WEST SUSSEX COUNTY COUNCIL CONSULTATION

TO:	Arun District Council FAO: Maria Tomalova
FROM:	WSSC - Highways Authority
DATE:	1 March 2022
LOCATION:	47 Golden Avenue, East Preston, BN16 1QX
SUBJECT:	K/6/22/PL Erection of a detached dwelling and integral garage (resubmission following K/51/21/PL). This application is in CIL Zone 4 and is CIL Liable as new dwelling.
DATE OF SITE VISIT:	N/A
RECOMMENDATION:	Advice
S106 CONTRIBUTION TOTAL:	N/A

GROUND FLOOR

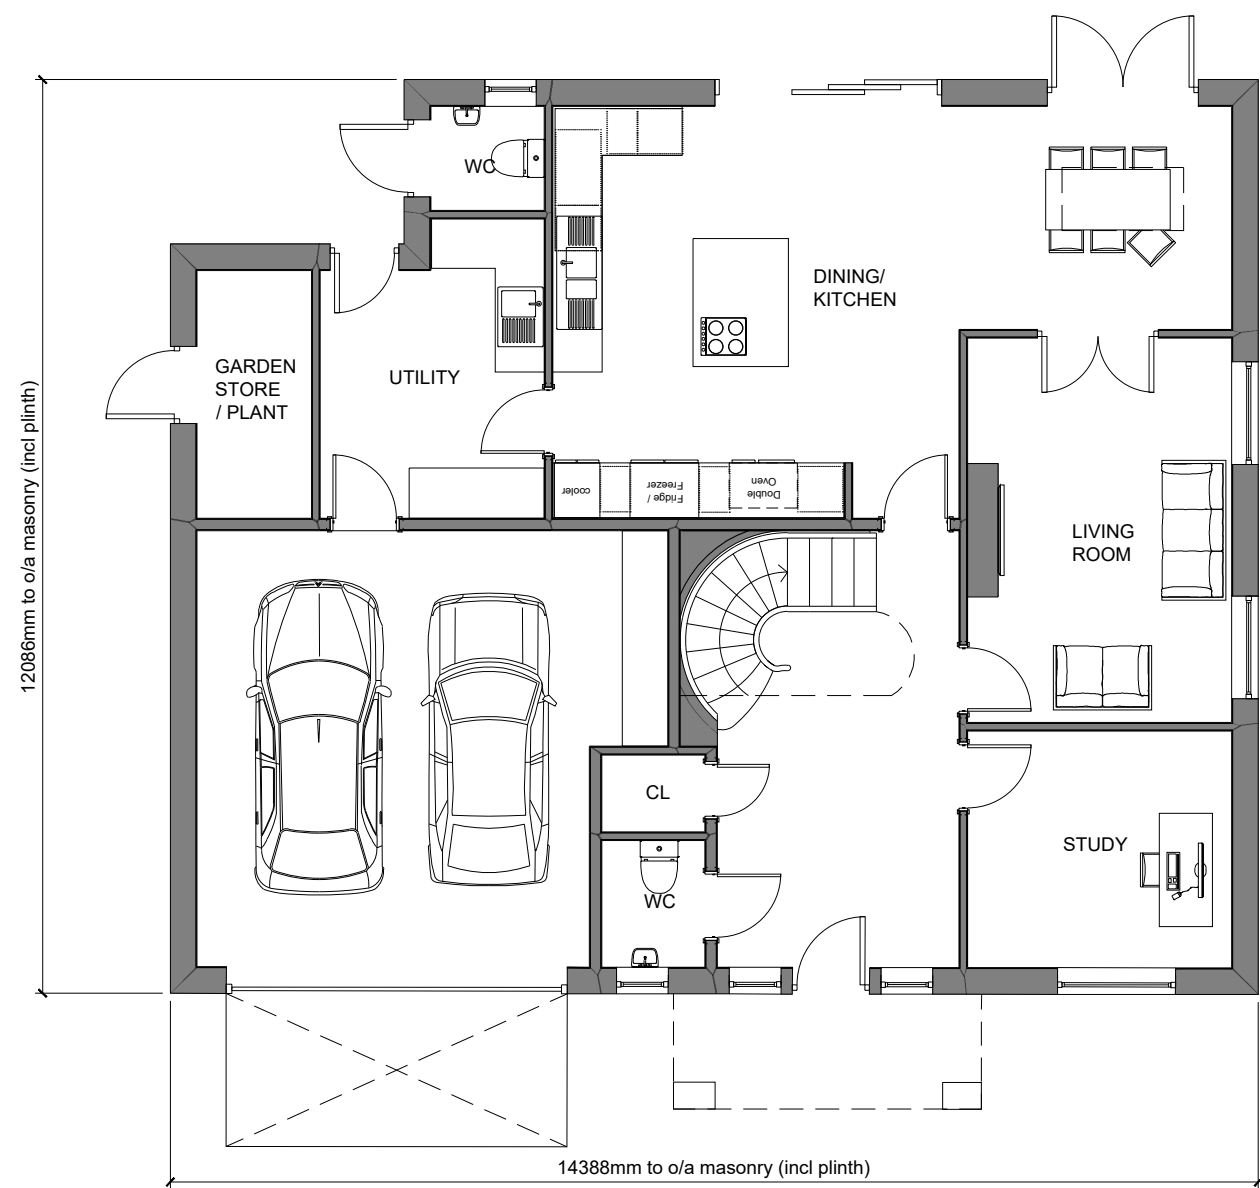
The applicant proposes a new in/out access onto Golden Avenue. The applicant is advised to contact the proprietor of the privately maintained road to obtain formal approval for the proposed access works. From inspection of the plans, there are no apparent visibility issues with the proposed points of access. The LHA does not anticipate that the addition of one dwelling would give rise to a material intensification of movements to or from the site.

For vehicular parking, the applicant proposes a double-bay integral garage with driveway. Under Arun Parking Standards, the LHA would expect a dwelling of this size in this location to provide at least three car parking spaces. Therefore, the LHA considers the proposed parking provision to be sufficient. From inspection of the plans, the garage and driveway are suitably sized to accommodate the parking requirement and on-site turning appears achievable.

Regarding cycles, the garage is of suitable size to be considered for secure cycle storage, in accordance with Arun Parking Standards. The inclusion of cycle parking helps promote the use of sustainable transport methods.
